Recommendation: Refuse

Applicant: Mr & Mrs Purewal

Proposal: Erection of 4 No dwelling houses with associated garages, access and landscaping

Drawing Title:
Proposed Site Plan & Layout

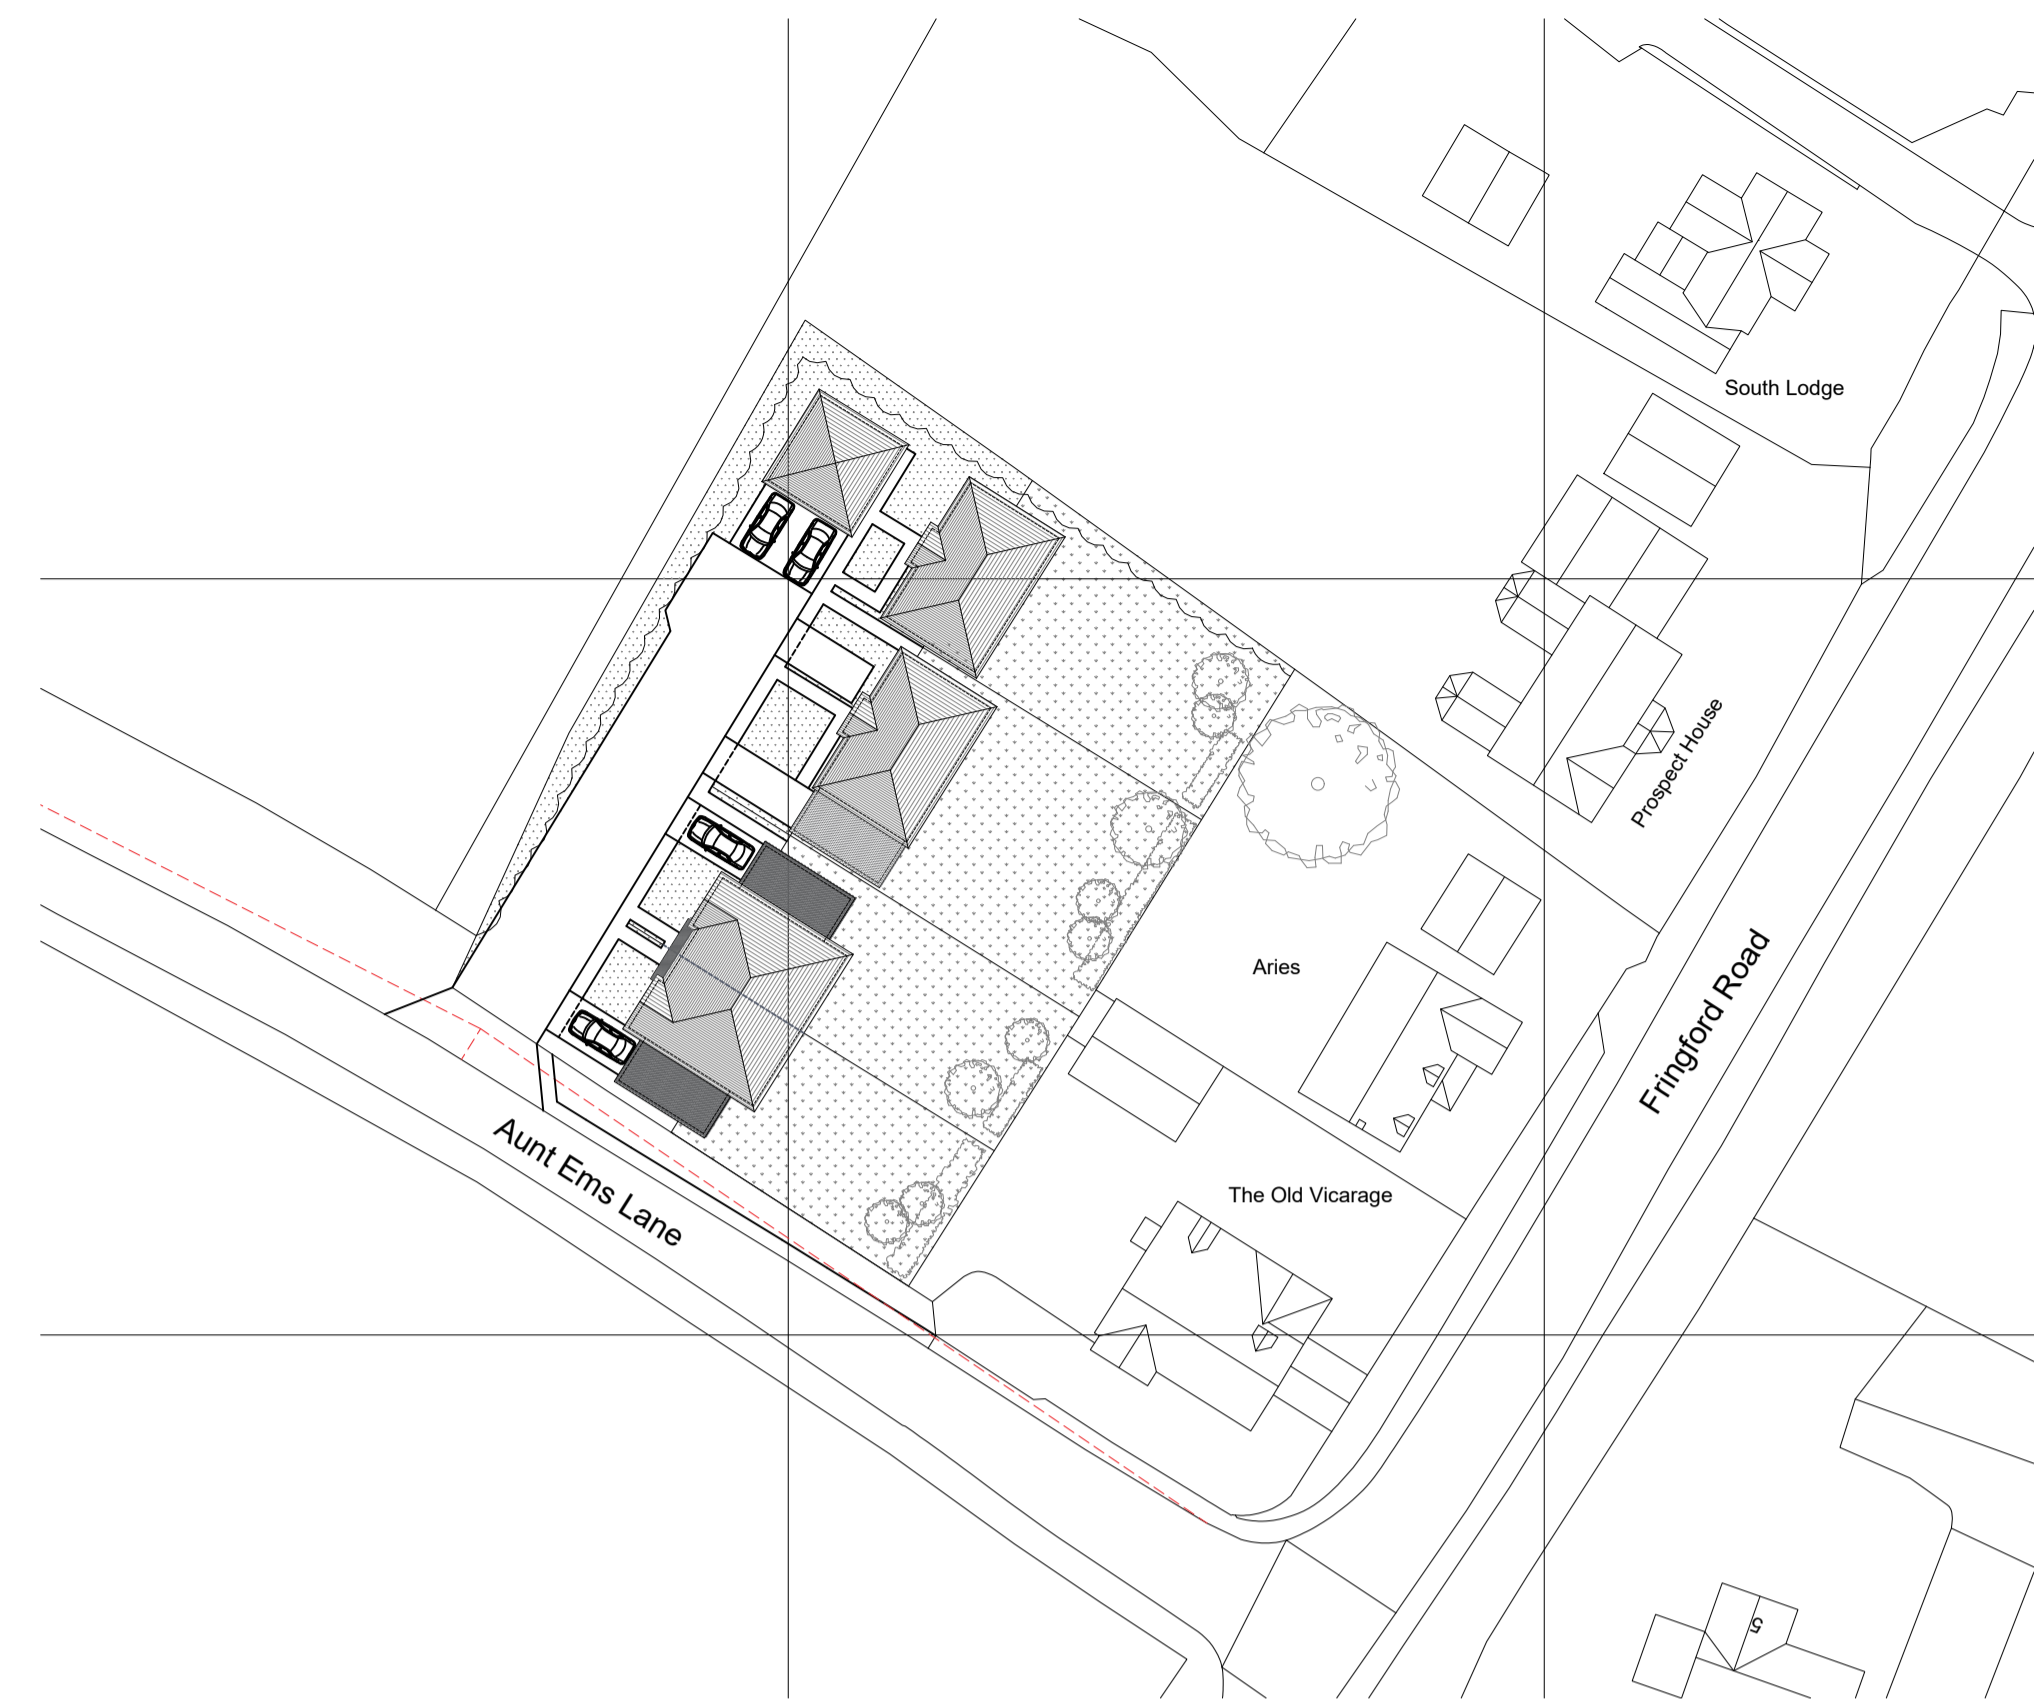
- 8.22. The existing cluster of properties located to the east of the site have accesses which front onto Fringford Road in a ribbon pattern. Whilst the vehicular access and orientation of the Old Vicarage is onto Aunt Ems Lane, there is a continuation of this ribbon pattern around the street corner. The current application seeks consent for a new cul-de-sac which would give individual vehicular access to each property. This development pattern is not a character of this immediate area and would contribute to an urbanisation of this area of land and thus impacting negatively on the rural character of the site wider area.

- 8.23. The existing cluster of dwellings to the east of the site are all moderate size and within generally spacious plots, with generous separation distances between each. This contributes to the semi-rural nature of this part of the village, aiding the transition towards the countryside to the south and west. The distance across the frontage of all these 4 existing residential properties is measured at approximately 100m, whilst the space afforded across the application site to accommodate 4 further dwellings is approximately 50m. The volume of housing on this site, and the housing density above that of the surrounding area is considered inappropriate in this location, failing provide a sympathetic layout to respect the existing pattern of development and failing to complement or enhance the character of the context.

- 8.38. The Local Highways Officer has objected to this application, on the basis that the submitted site layout plan does not show the full extent of the visibility splay to the west of the access, nor any dimensions and therefore it has not been demonstrated that the development achieves the required visibility splay within the highway boundary, which is required prior to the determination of an application.

- 8.39. Whilst there is an existing garden access gate into the application site, this is not the primary vehicular access for occupiers of The Old Vicarage, which is further to the east. In any case, the proposed access into the site is located further to the west than the existing site/garden access. Officers see no reason to disagree with this assessment and, in the absence of any plan or information which demonstrates an acceptable visibility splay, conclude that the proposal would result in an unacceptable impact on highway safety.

Drawing Title:
Proposed Street Elevations

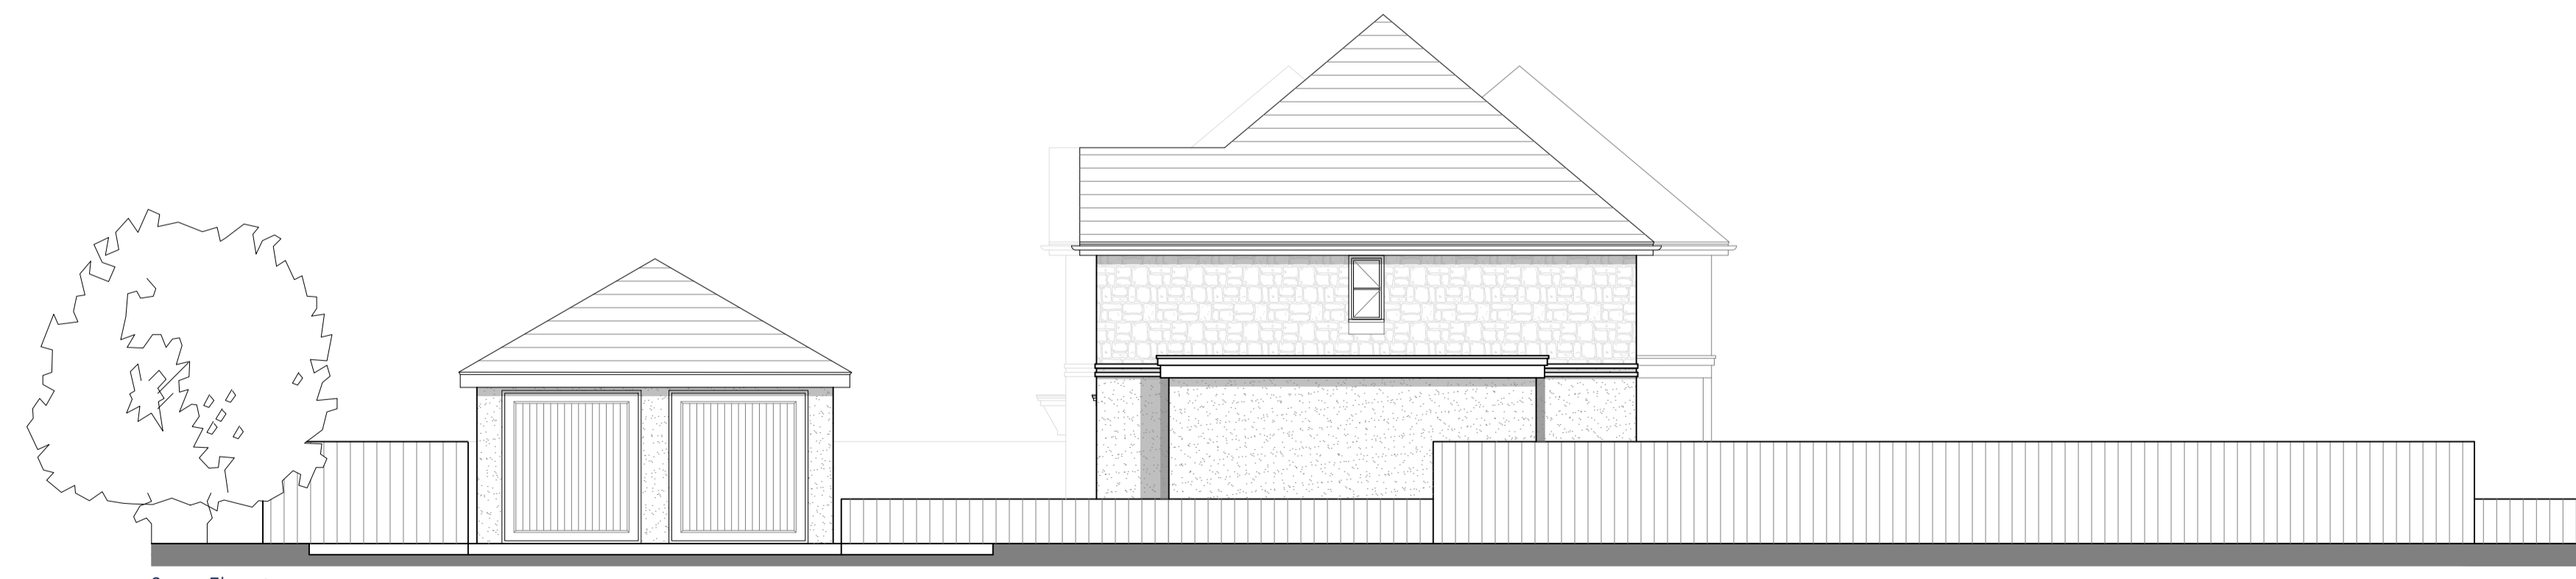
- 8.24. The heights of the semi-detached dwellings at Plots 1-2 is considered particularly harmful to the character and appearance of the wider area, being 9.5m at ridge and thus above the height of the Old Vicarage being over-dominant in the context of the overall streetscene and in public views along Aunt Ems Lane.
